Certificate of Occupancy

LOCATION 41 Hutchins Dr

MEMORANDUM

TO: Kevin Carroll, Code Enforcement Officer
FROM: Steve Bushey, Acting Development Review Coordinator
DATE: August 9, 1996
RE: Temporary Certificate of Occupancy for 41 Hutchins Drive

**B SILTATION FENCE**  
 C-3 N.T.S.

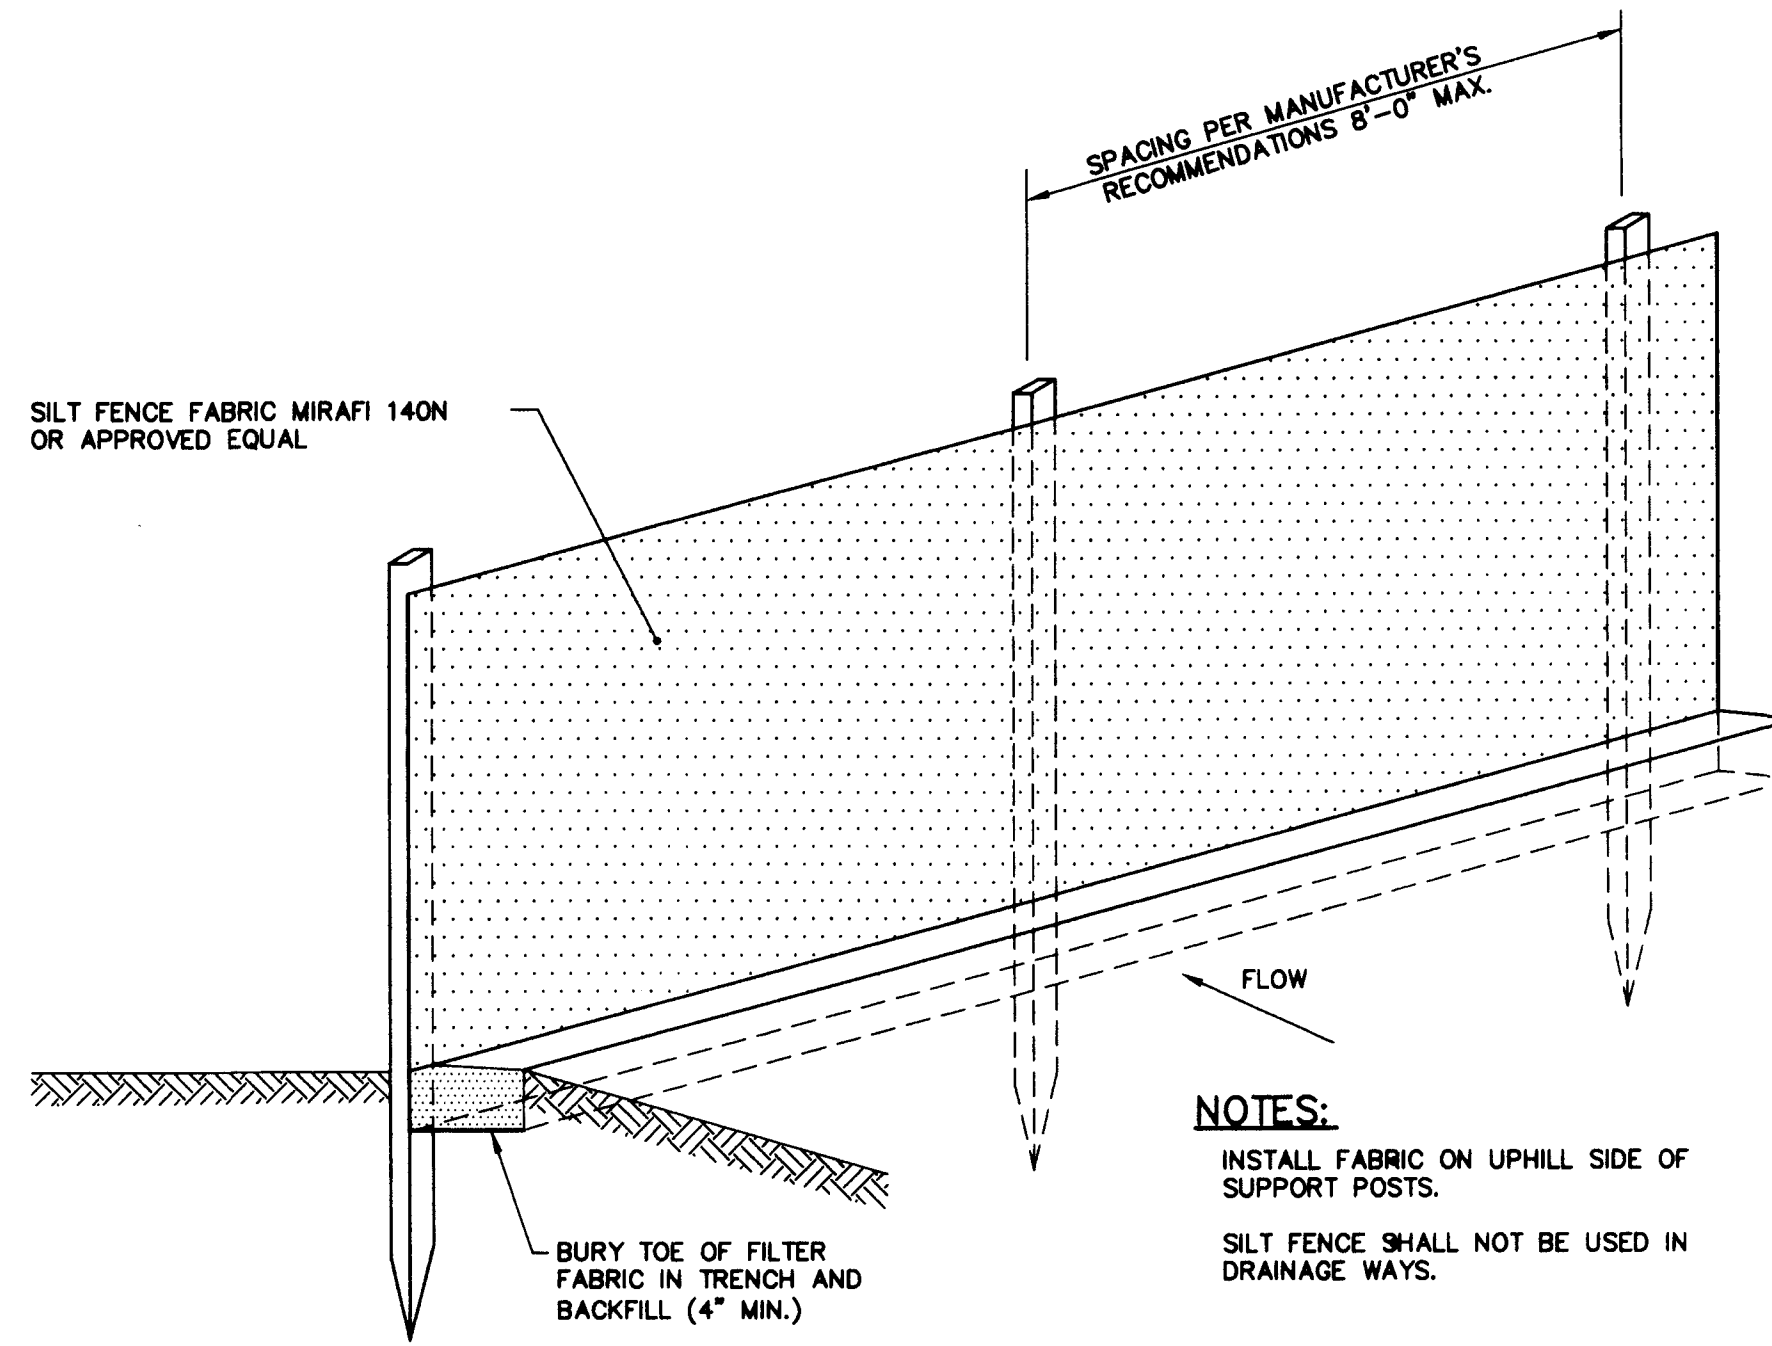
1. The silt fence surrounding the site should be removed.
2. There are several significant eroded rill gullies on the embankment along the outside of the lower parking field and beside the building; they should be repaired.

**I RIPRAP APRON**  
 C-3 N.T.S.

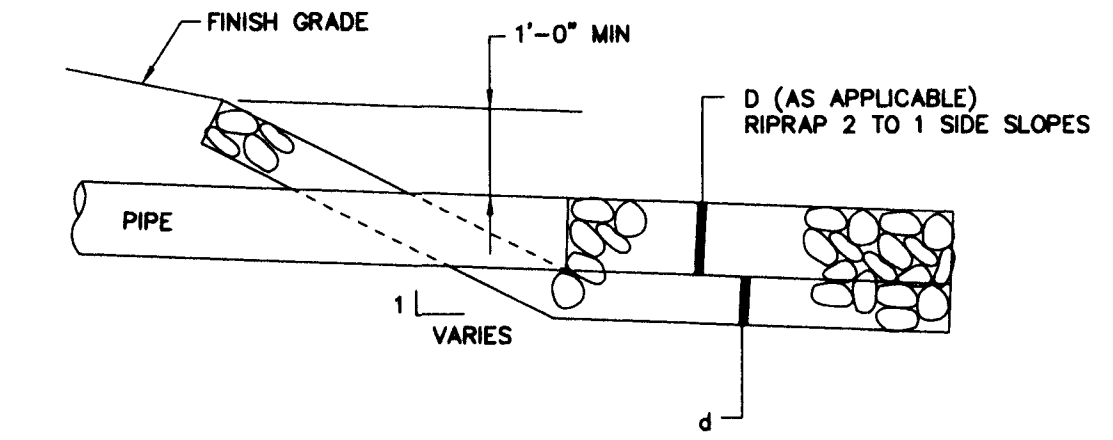
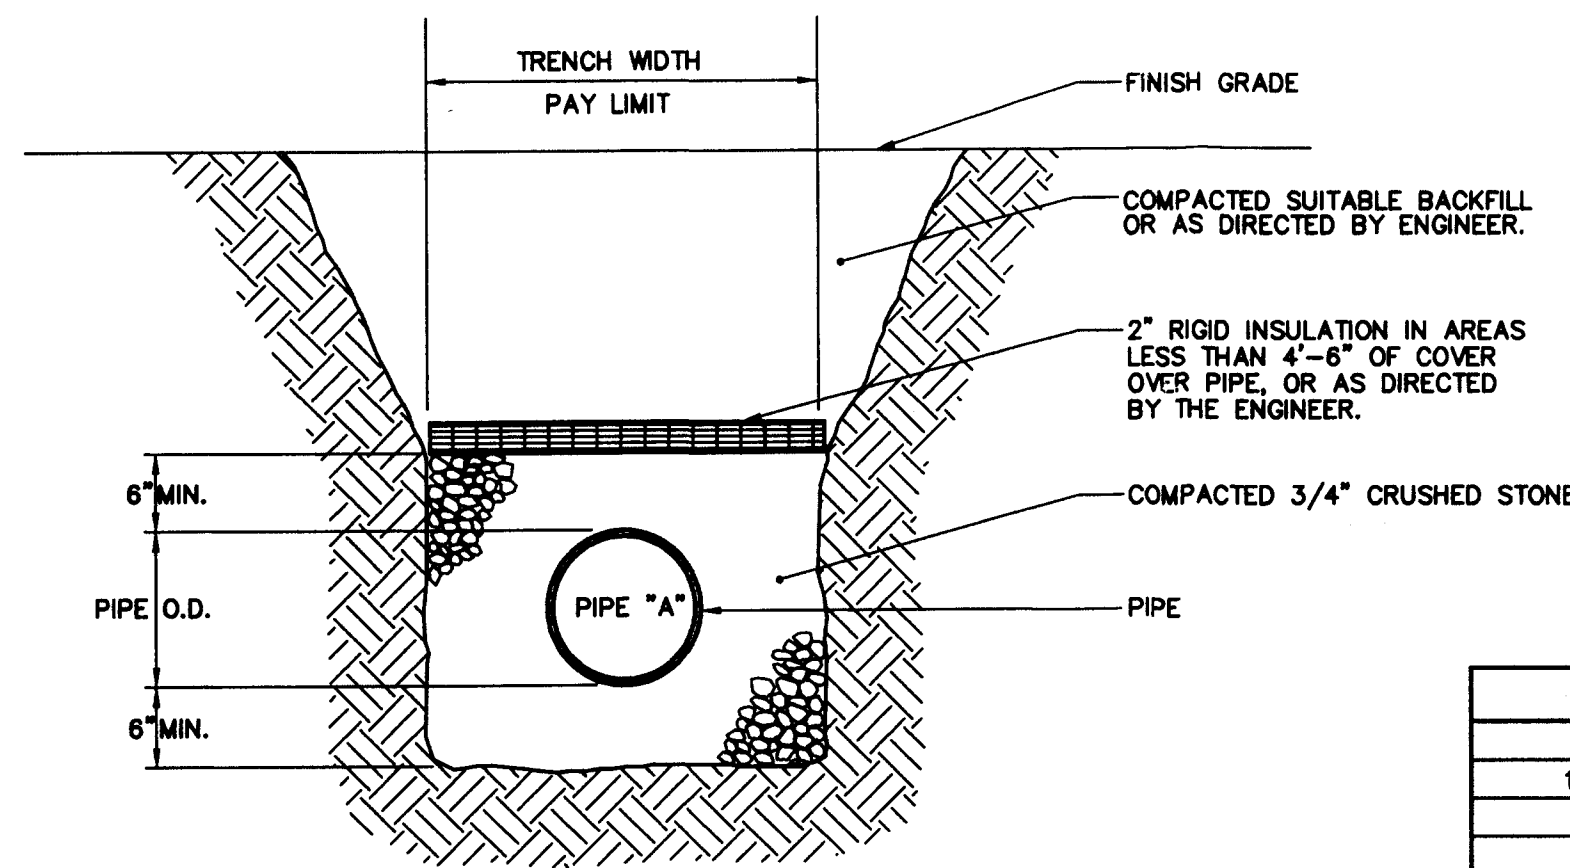
4. The stormwater flow from the inlet pipe to the detention basin has eroded a small area at the end of the pipe. Recommend that some riprap be placed around the end of this pipe to stabilize the bottom of the detention basins; recommend a d50 stone size of 4" - 6".

**F POND OUTLET**  
C-3 N.T.S.

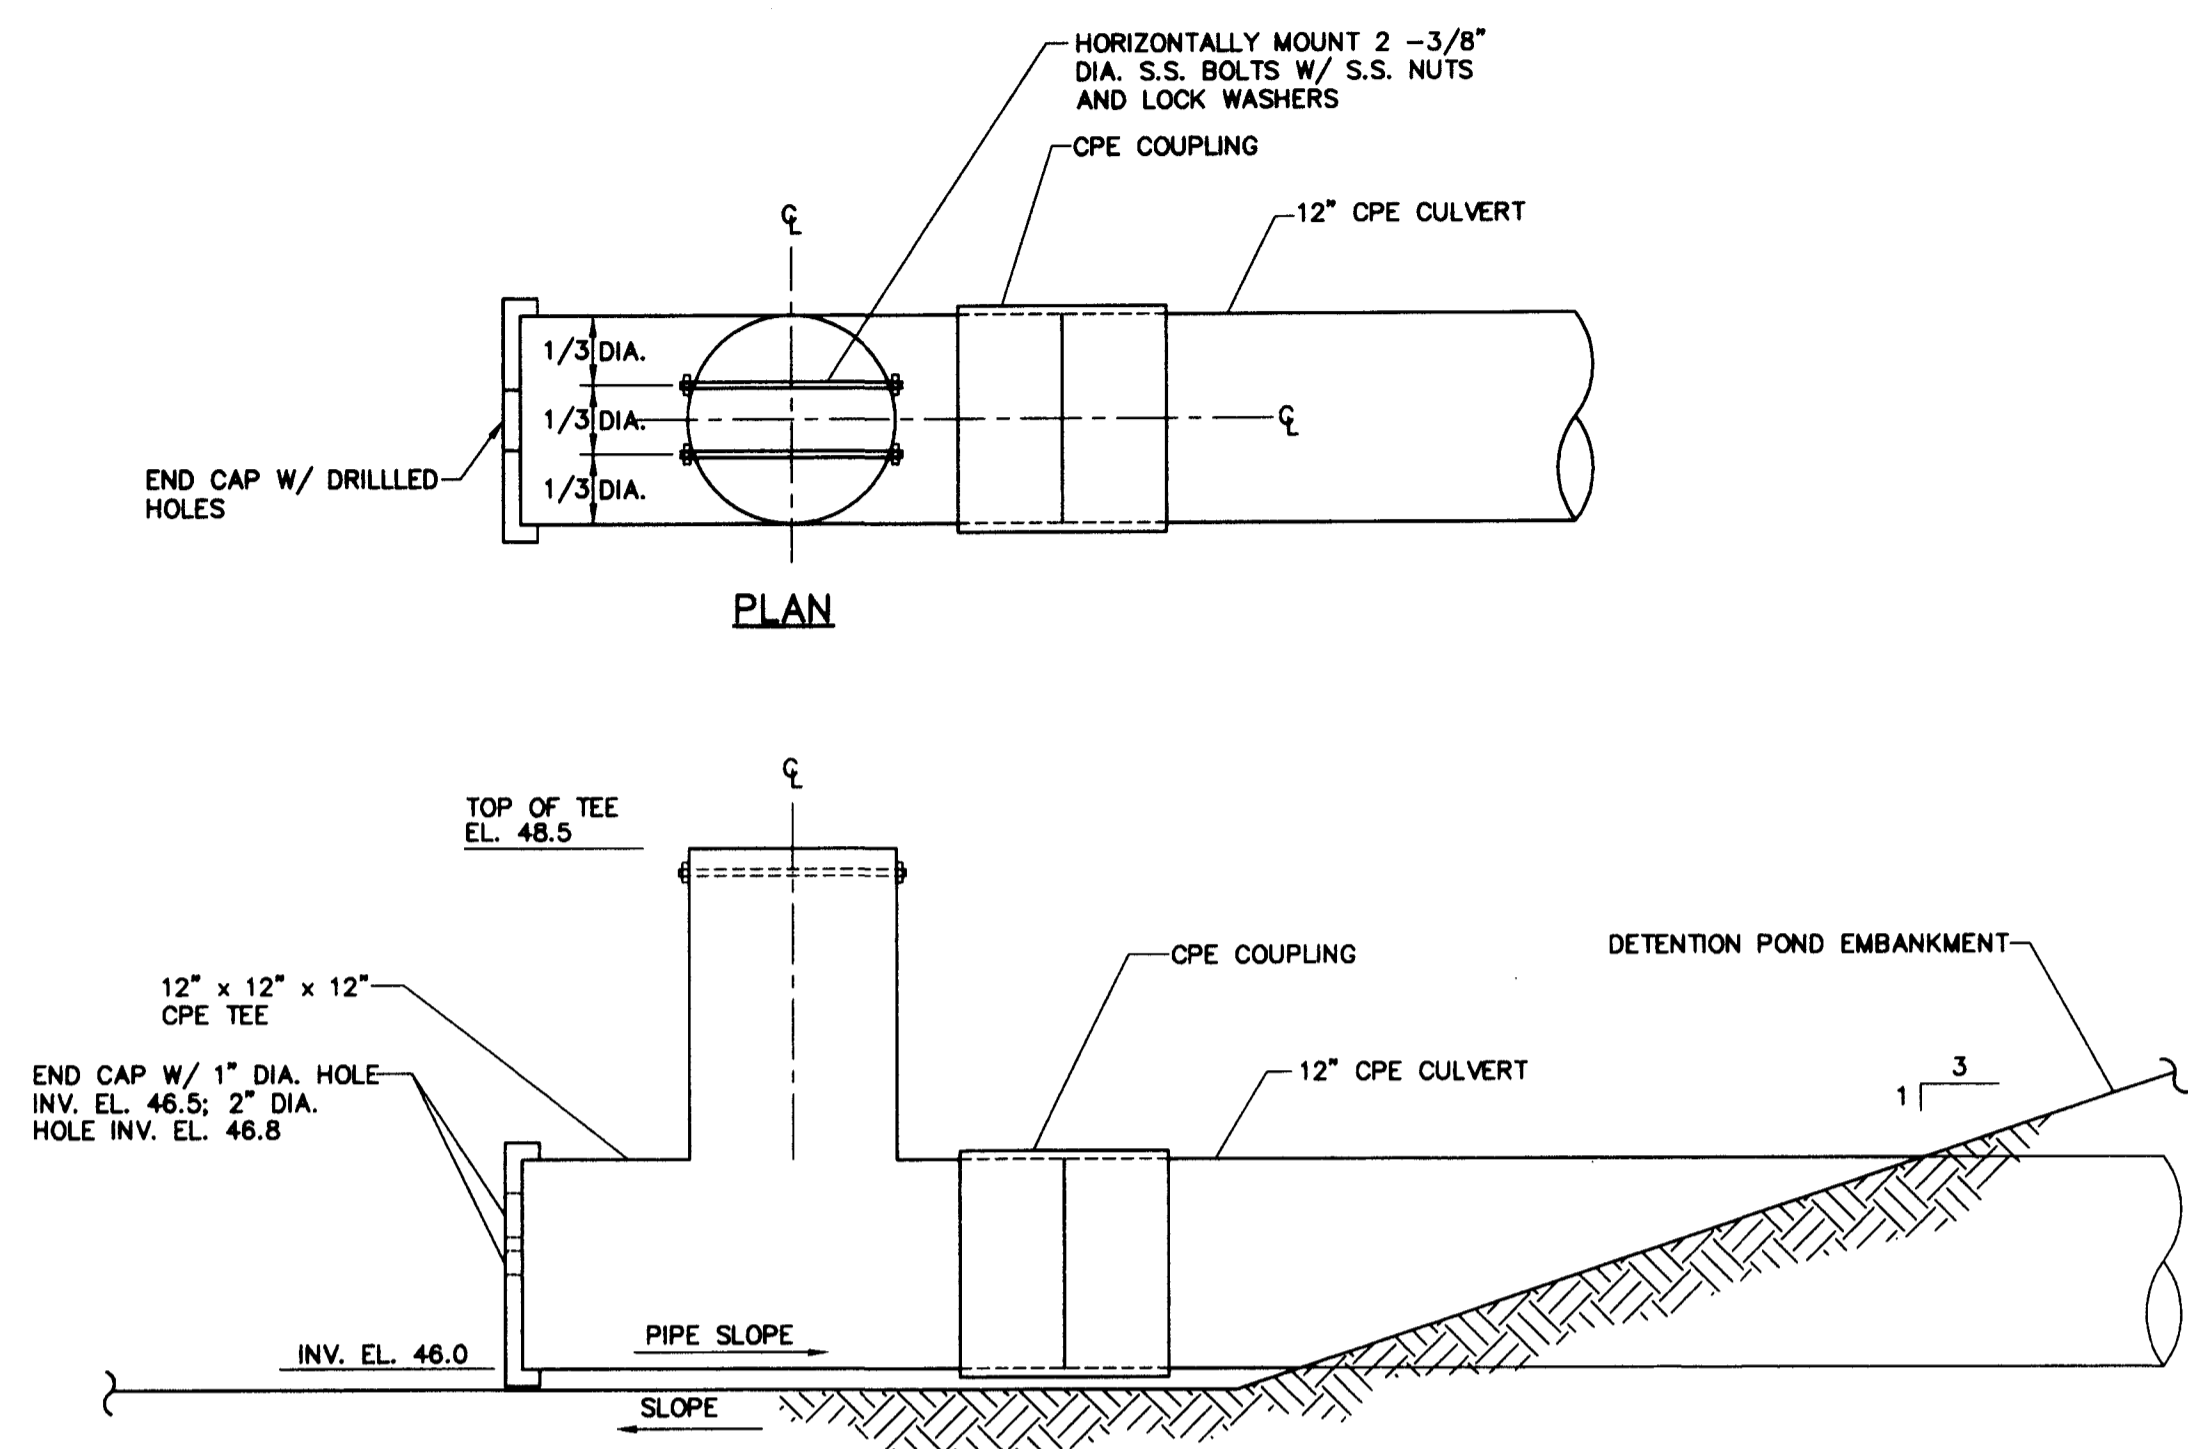
5. Significant amounts of soil eroded from the detention basin embankment has been deposited in the detention basin; the soil should be removed and the disturbed bottom stabilized with grass.
